Dear Manston Airport Case Team. Thank you for your prompt and informative reply.

Please see this as a draft written submission to the Examining Authority setting out the representation I would have made orally at an OFH.

Draft Submission

Figure 6.19
Annual mean PM_{2.5} process contribution (excluding roads), Year 20, (wider area)

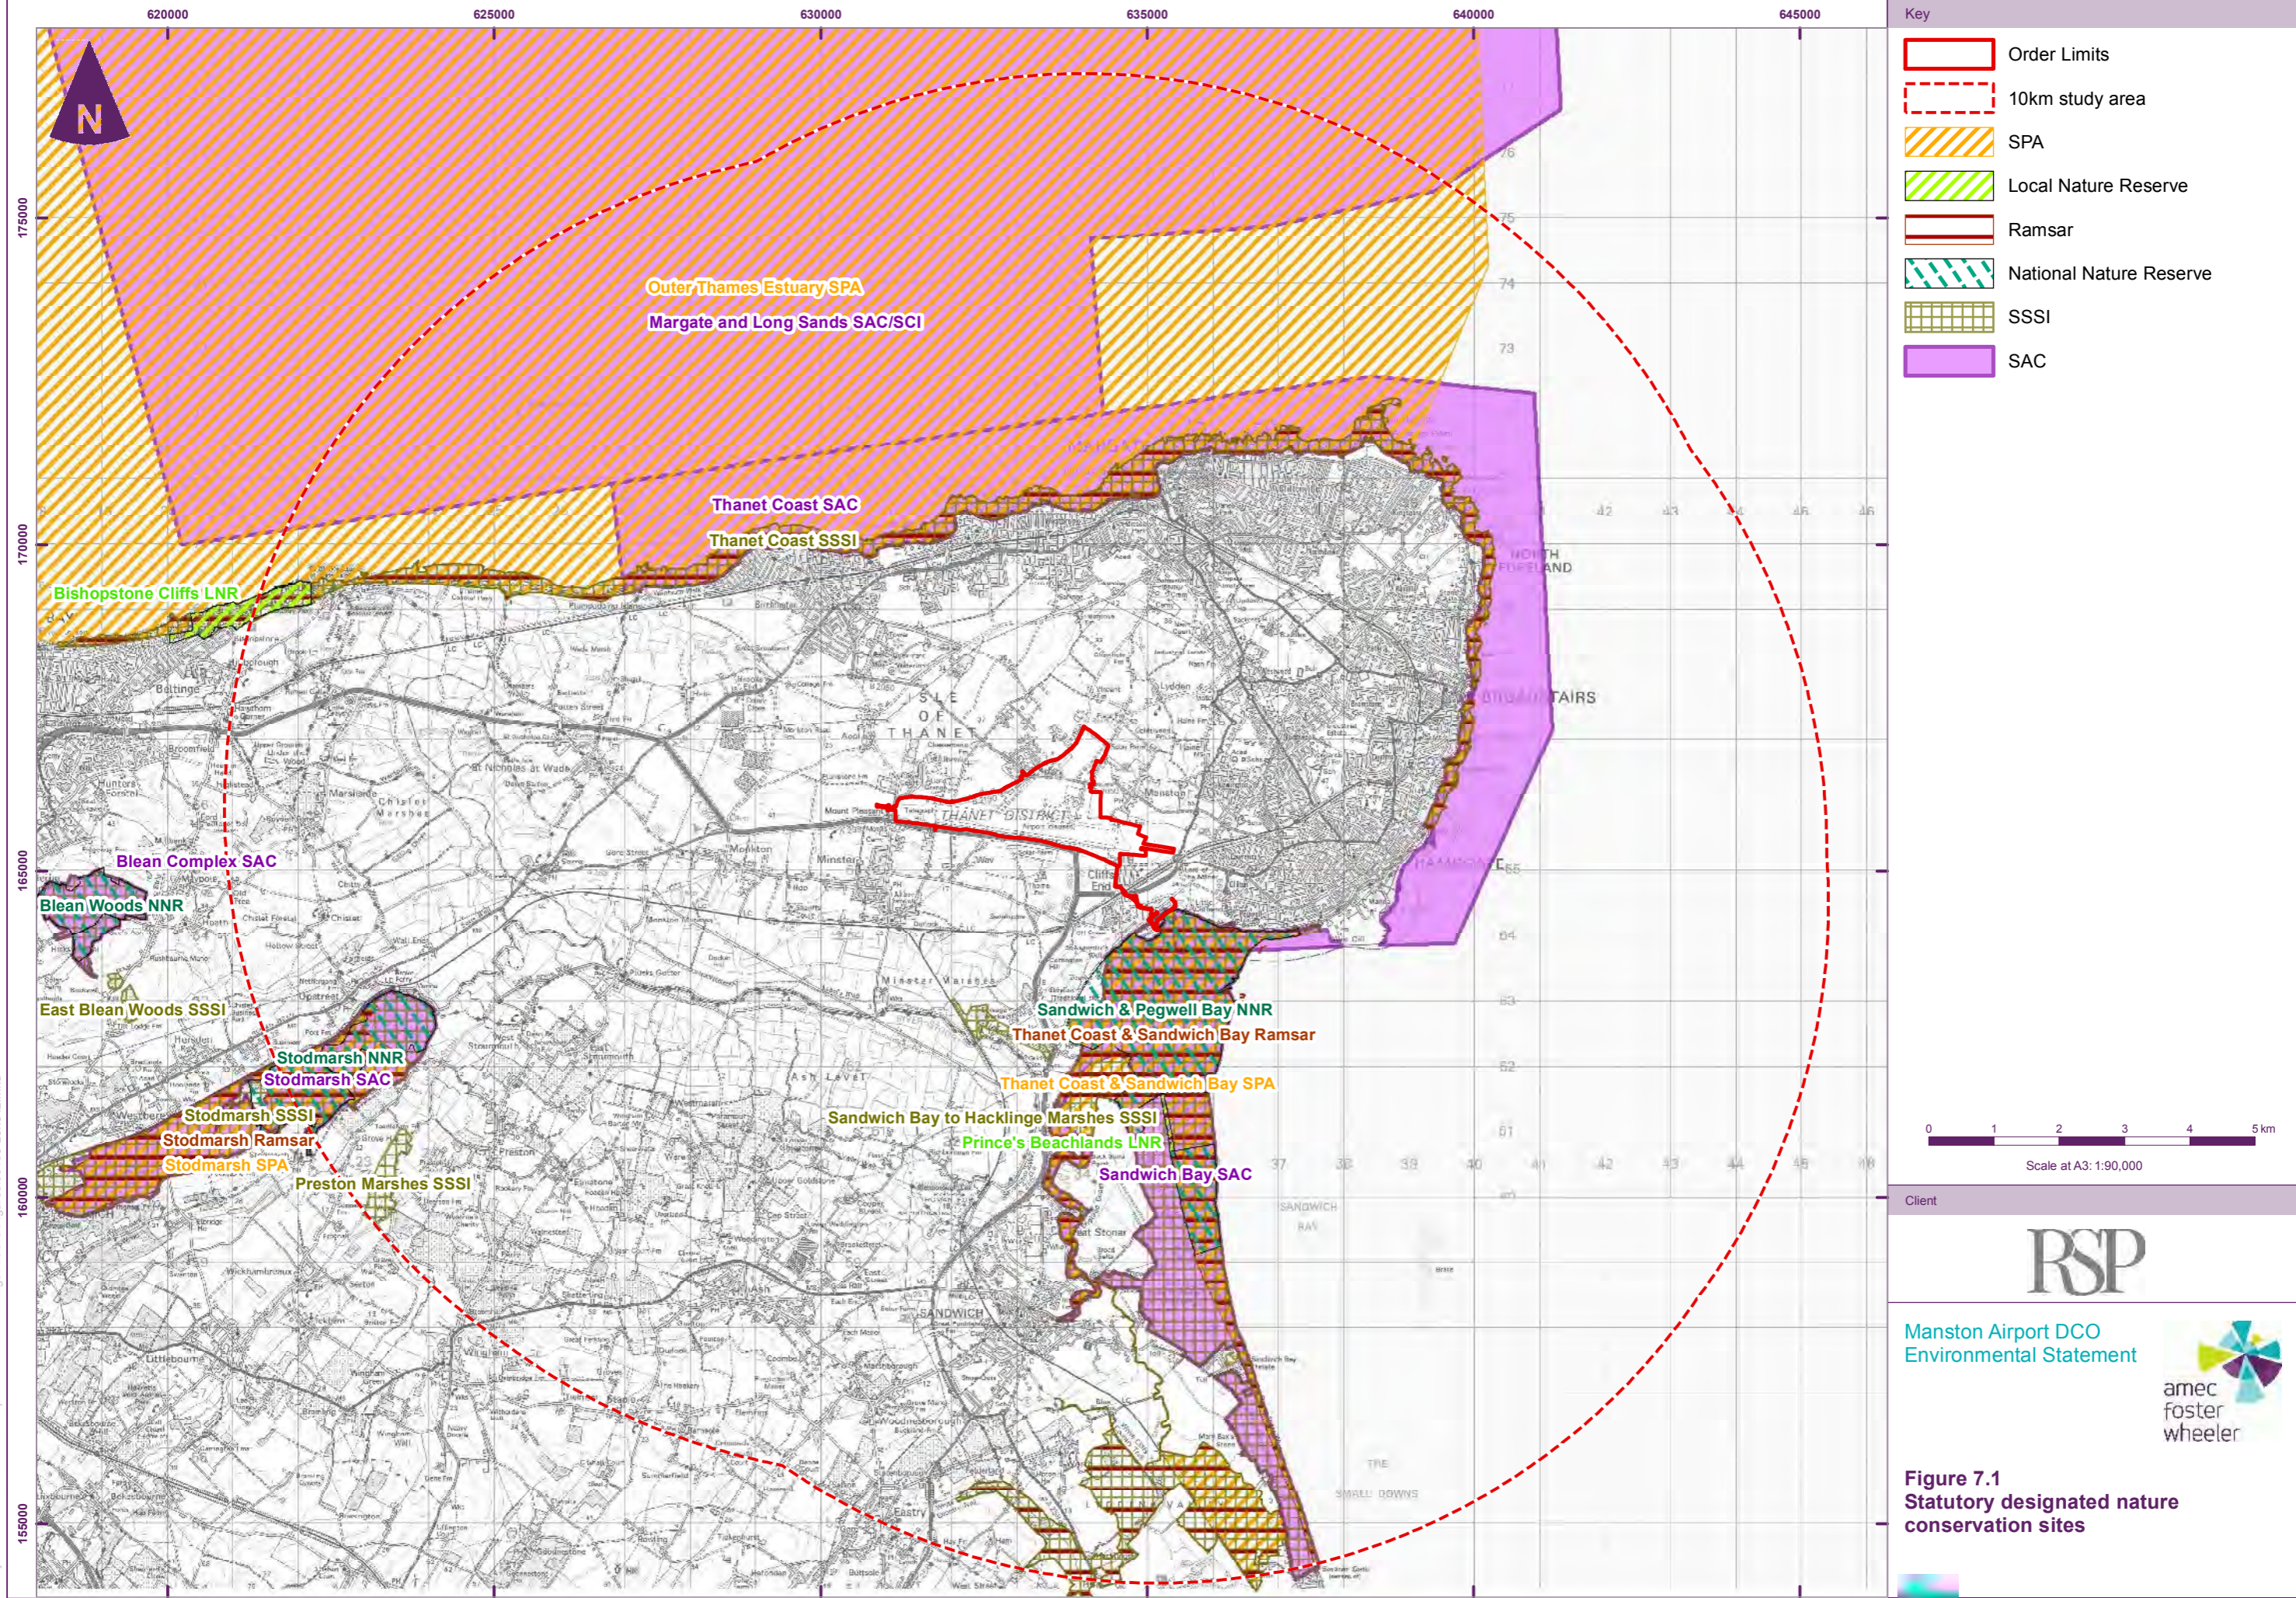
In a recent series of communications I pointed out that there had been an error in the environmental statement, which boiled down to the applicant not allowing for the fact that smaller particles remain airborne for longer than larger ones.

I am assuming that you understand that there is a very large difference between the distance pm10s and pm2.5s travel when airborne.

“Particles within the two size ranges behave differently in the atmosphere. PM2.5, or fine particles, can remain airborne for long periods and travel hundreds of miles. Coarse particles, or the subset of PM10 that is larger than 2.5 μm , do not remain airborne as long and their spatial impact is typically limited because they tend to deposit on the ground downwind of emissions sources.”

The various figures you quote for PM2.5s seem to take the dispersion distance from the fuel burn to be about 1 km max i.e. the distance for PM10s.

“I am seeking clarification about the dispersion figures you are using for airborne particulates, this would normally be expressed as $\mu\text{g}/\text{m}^3$ against km from source, often presented in the form of a graph, could you kindly give me the figures you are using both for PM10 and PM2.5 particulates.”

I will be happy with the figure you are using for both PM10s and PM2.5s in km from the point of burn to 10% above background level if you are unable to provide dispersion graphs for both particle sizes.

More recently I have had great difficulty trying to get the applicant to follow the basic scientific rule that smaller particles travel further through the air than larger ones do.

I think it is pretty obvious that while PM10s are going to have dispersed to within 10% of background levels by the time they reach the airport site perimeter and so don't represent much of a public health threat PM2.5s will travel much further and will be at significant levels in most parts of Thanet at different times dependent on the wind direction.
